Together Against Sizewell C

24th June 2026

Reference EN010012

Notice of Application to make a Non-Material Change (NMC) to the Development Consent Order for the Sizewell C Nuclear Generating Station order 2022.

DRAWING TITLE:
 EXISTING RIGHTS OF WAY AND ACCESS

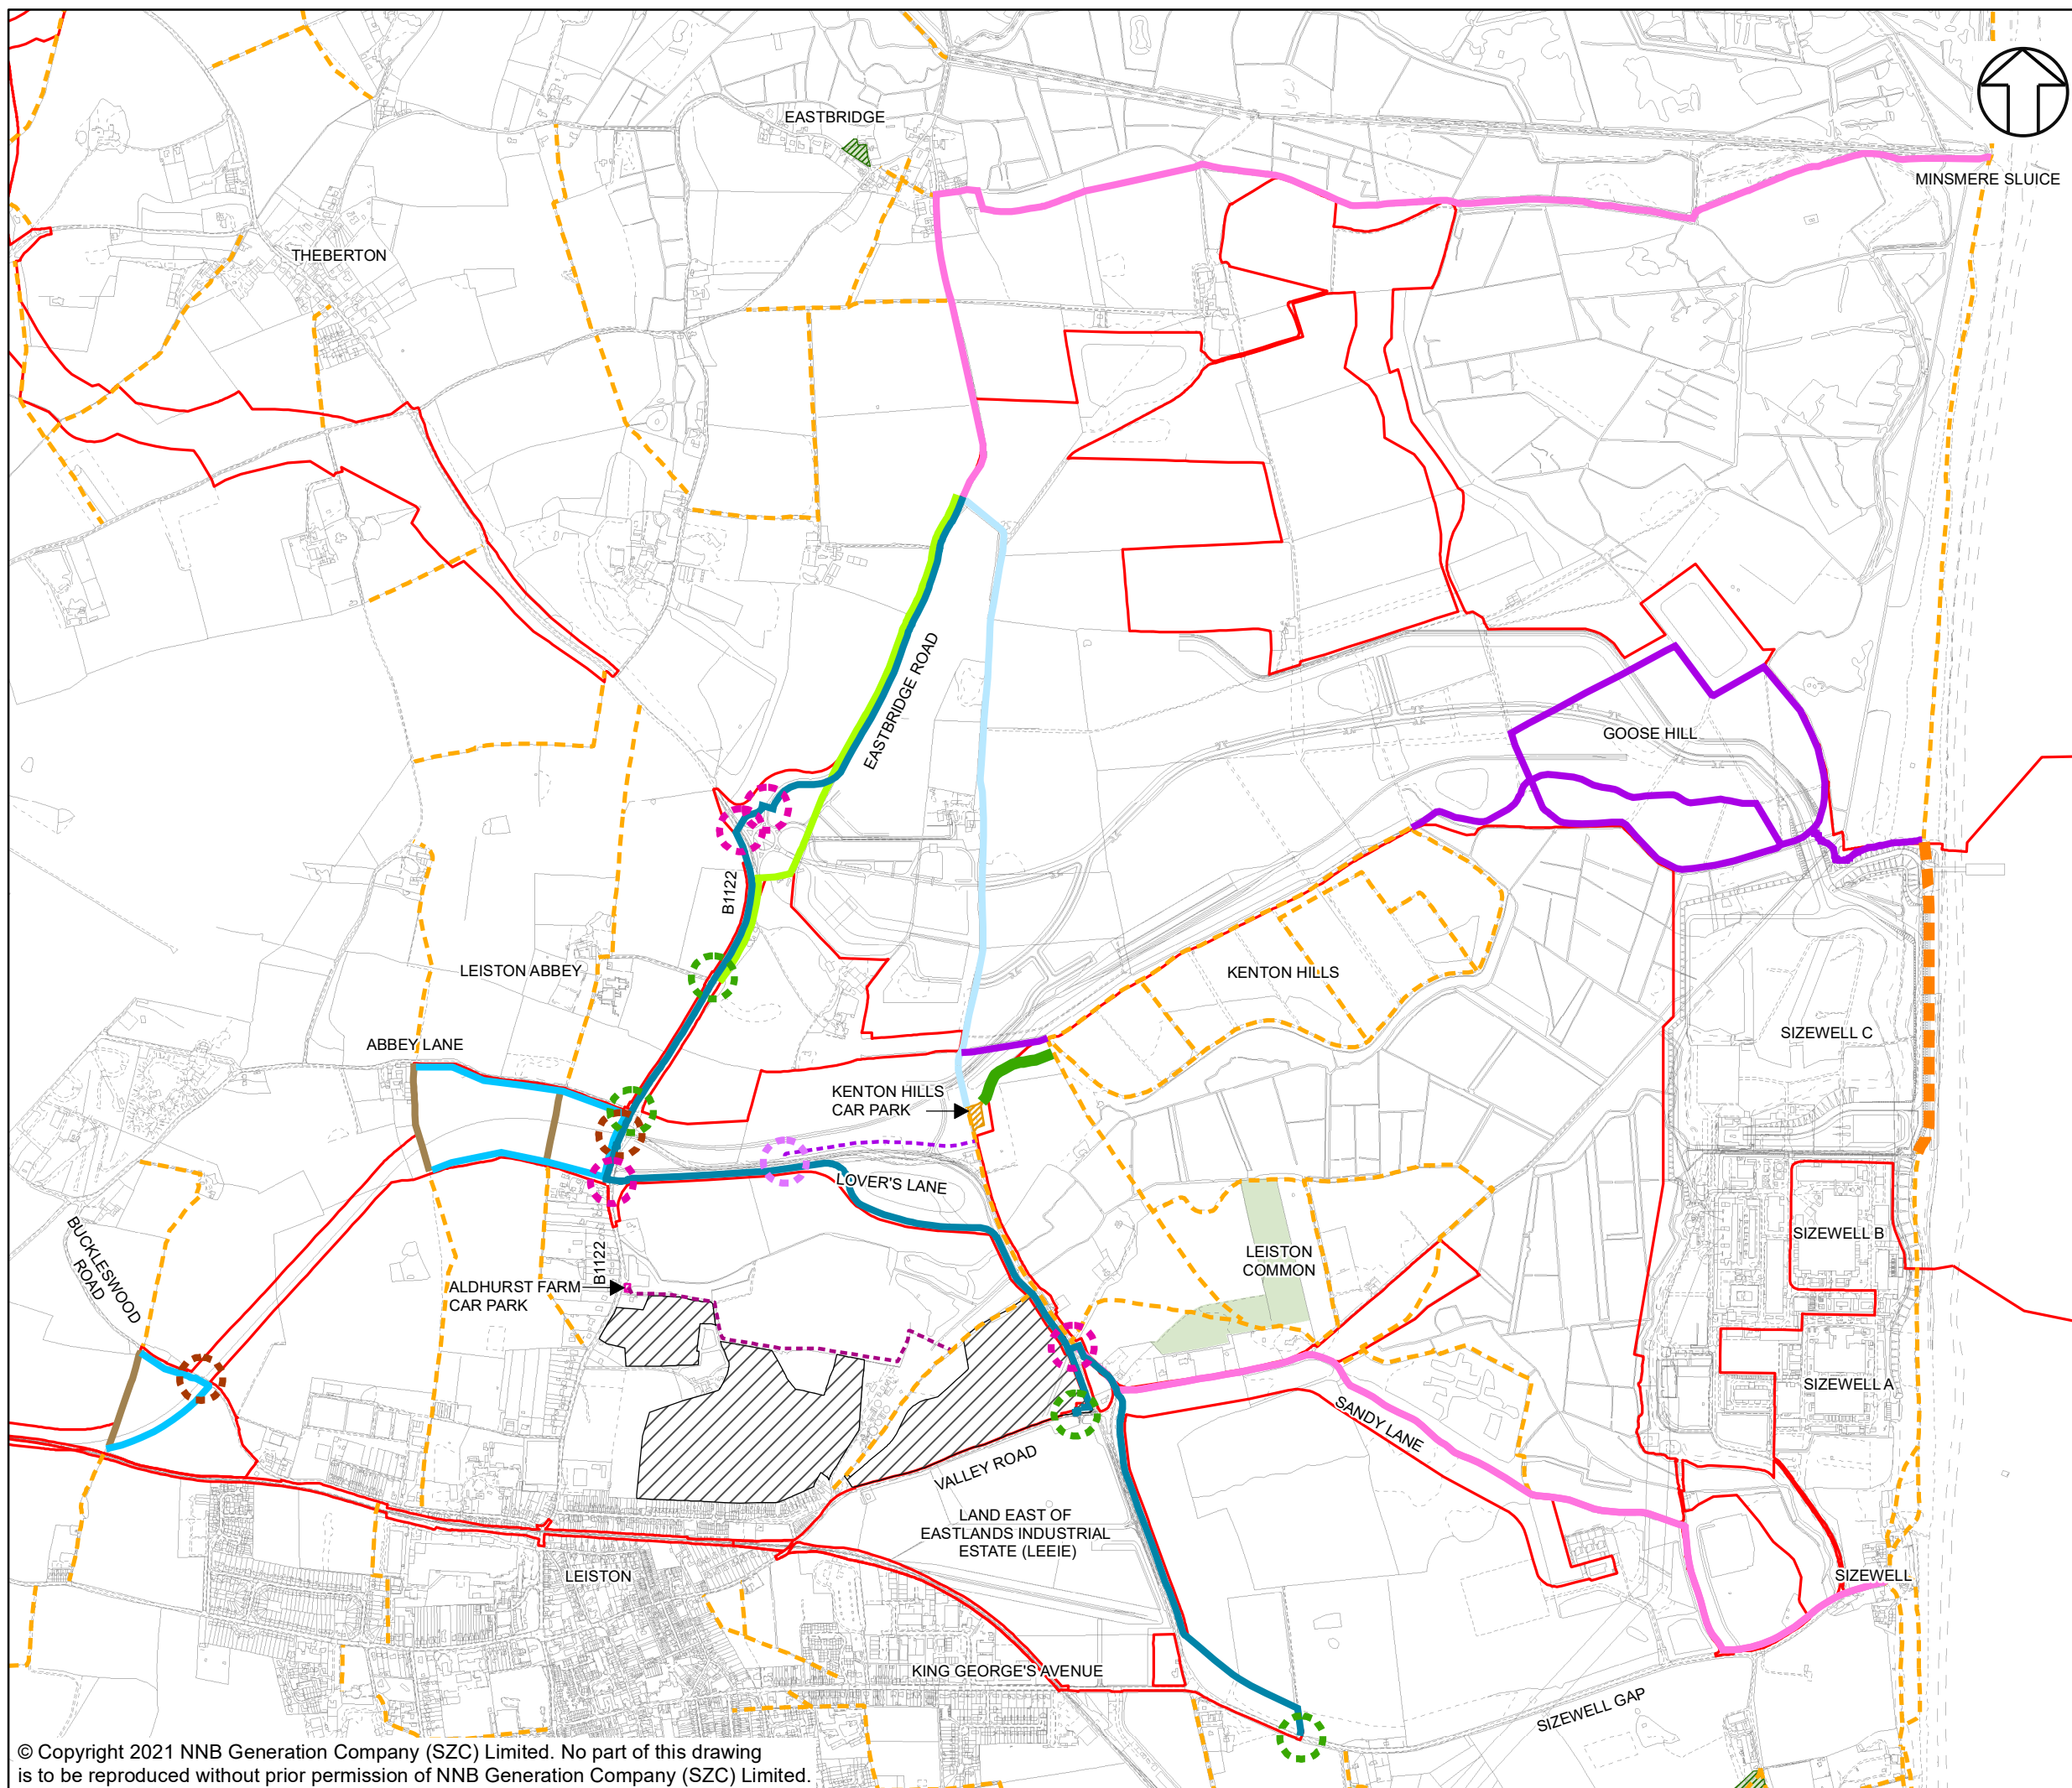
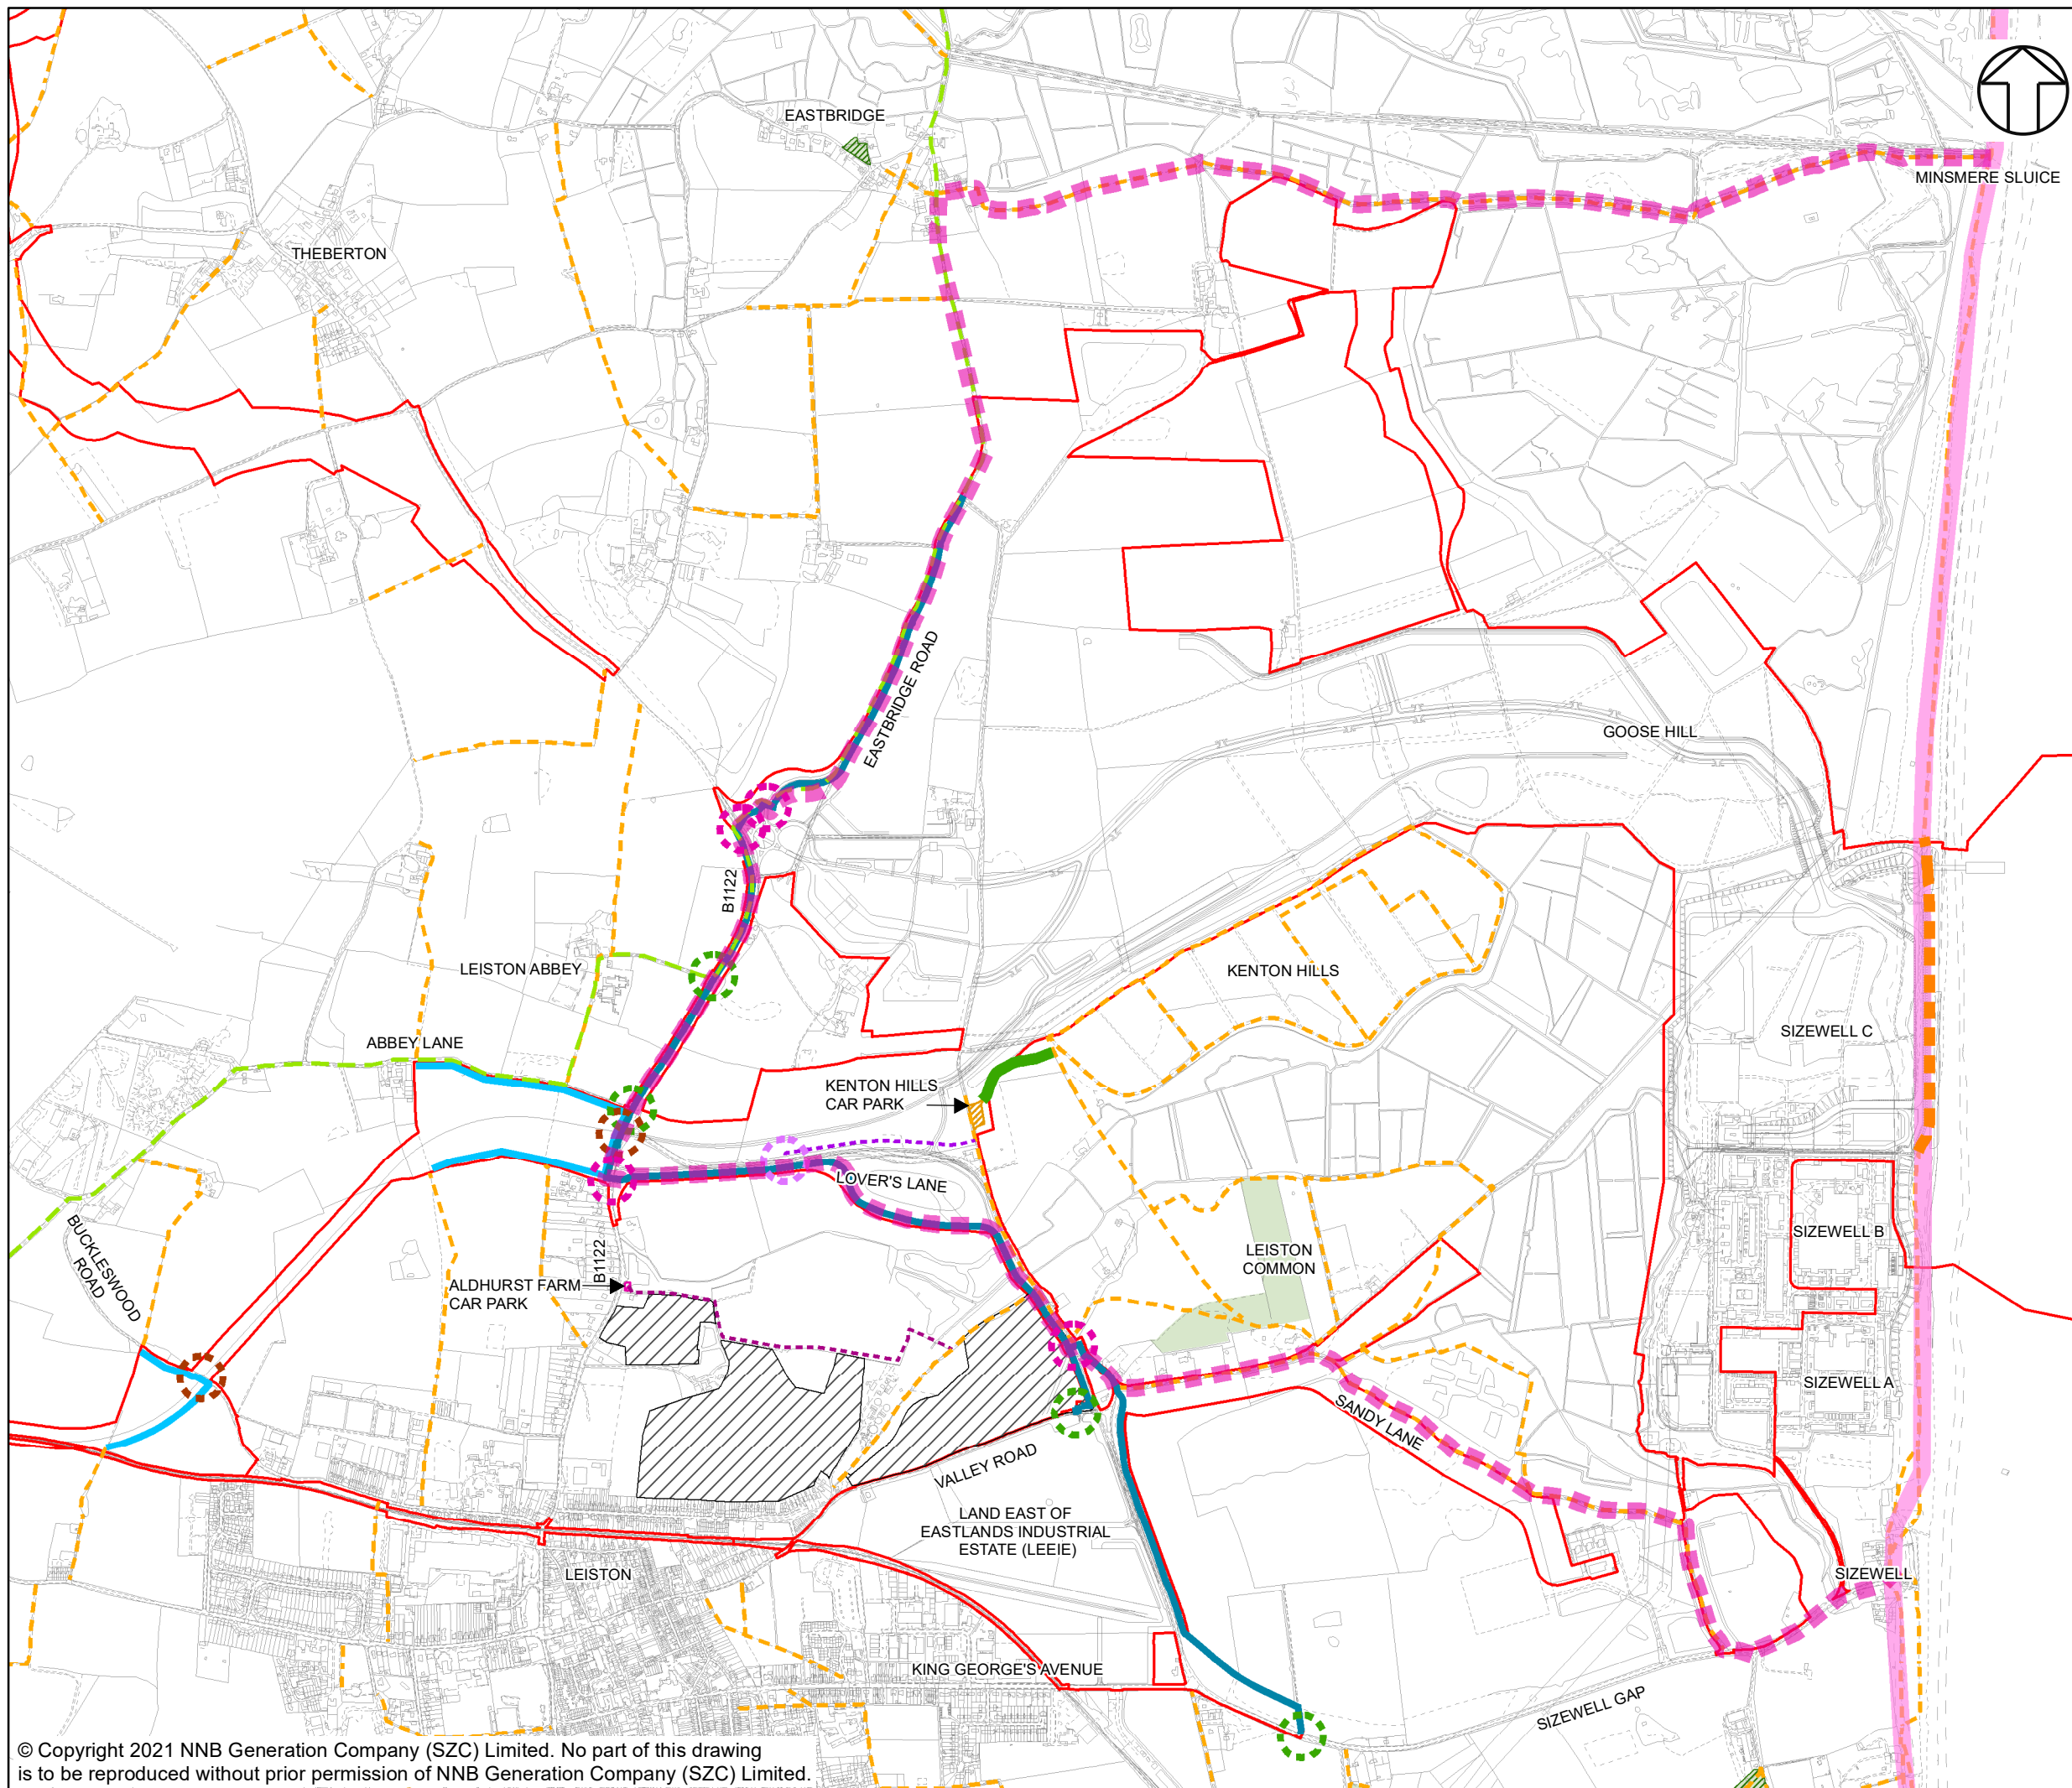
We consider that the diversions, stopping up and the closing of many Highways and Public Rights of Way (PROW) has been carried out for the benefit of SZC. Not enough consideration has been given to the many people who use the facilities, cutting off circular routes and long distance rights of way with inadequate, if any, consultation with the local parishes and necessitating making changes to the Ordnance Survey maps. This has potential negative impacts on the many tourists that make use of the PROW in the areas affected and therefore another negative impact on the tourism industry/businesses.
